Application for a non-material amendment following a grant of planning permission.
Town and Country Planning Act 1990

House:	3	Suffix:	
House name:			
Street address:	Shivean Gate		
	Moulton		
Town/City:	SPALDING		
Postcode:	PE12 6PL

Proposed 2 four-bedroom houses

H13-0283-16

Drawing No L158/PLOT 2/06	Rev.
------------------------------	------

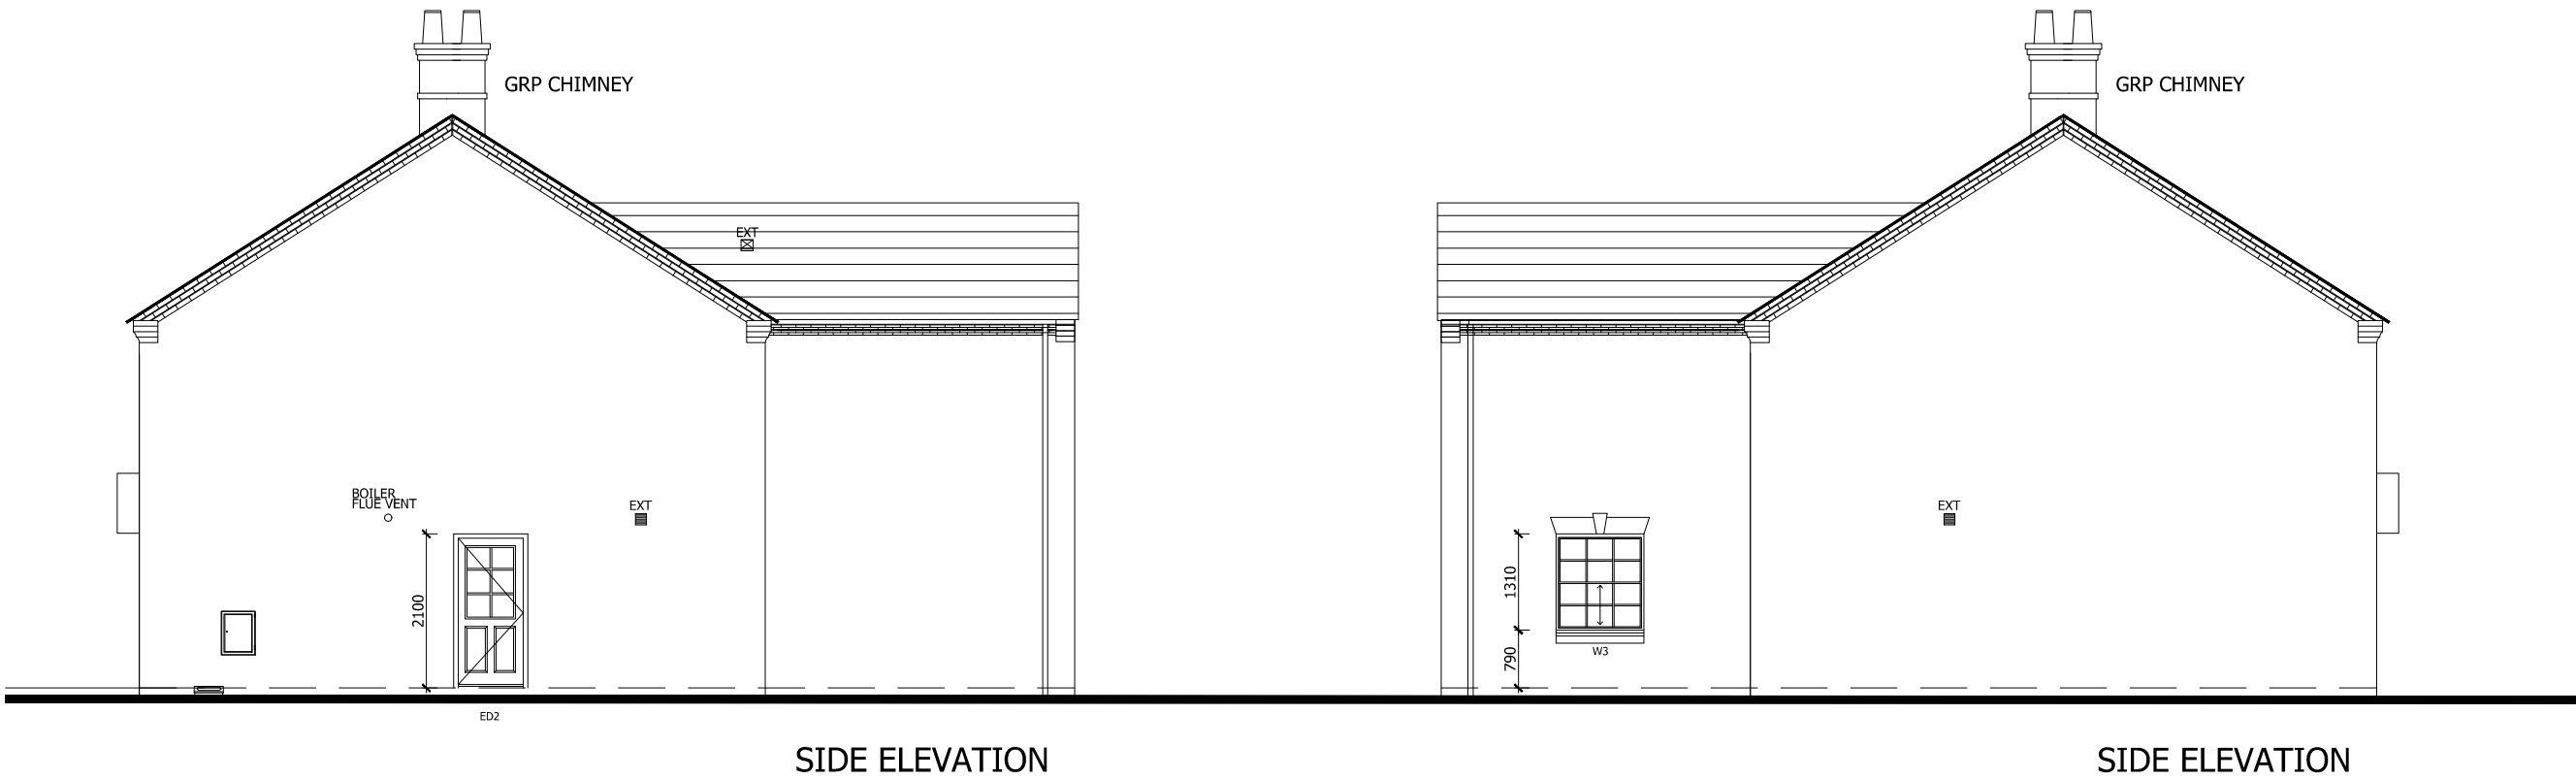
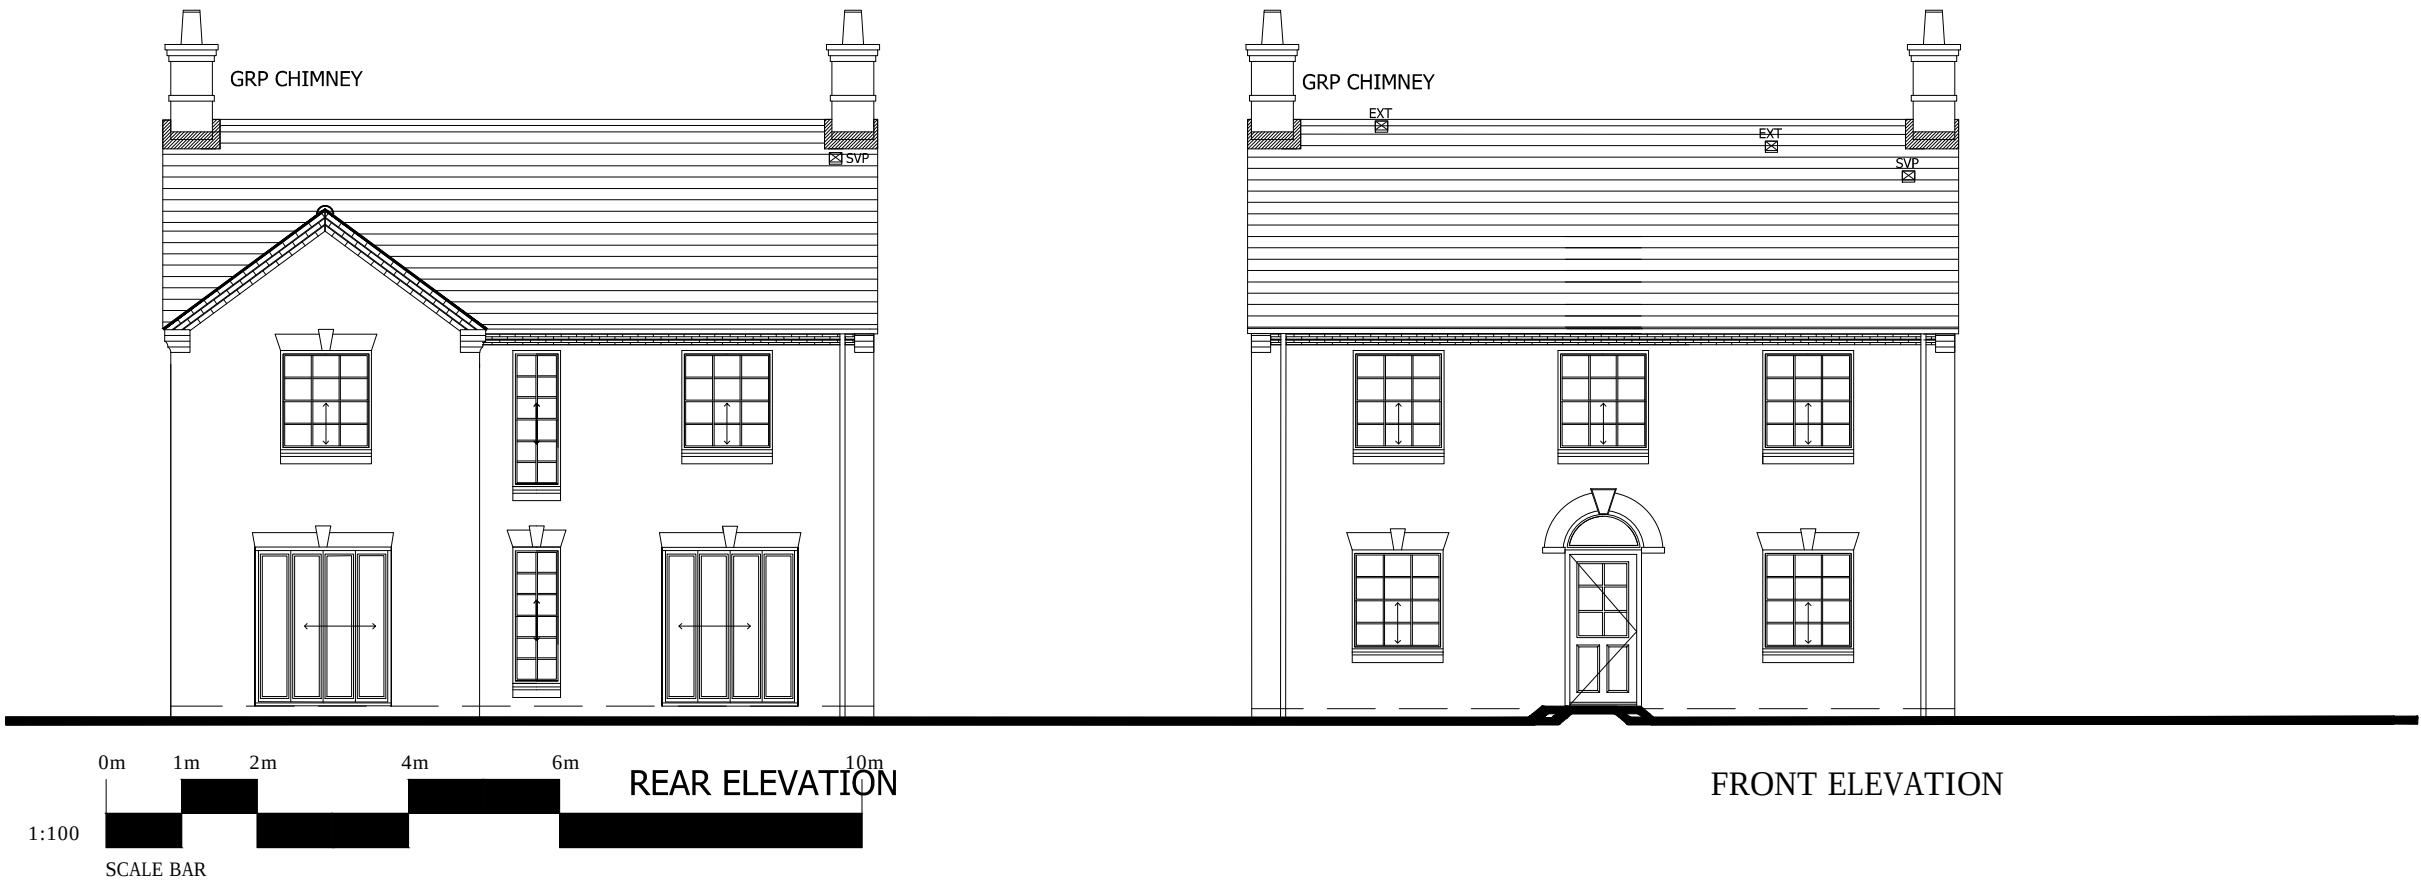
Omission of parapet walls along side gable of houses. Window design changes to reflect working drawings.

Once the plans were approved, the drawings were taken to the detailed technical design for the house types. Issues were raised in getting the GRP chimney working with the parapet detail on the houses.

Whilst drawing the elevations, alterations were made to the windows of the houses to work best with the property in providing sufficient light to each room and hallway whilst allowing for reasonable window widths for the central hallway.

Once the house details were drawn to correct building heights, this resulted in changes to the elevation of the houses in respect of window head design.
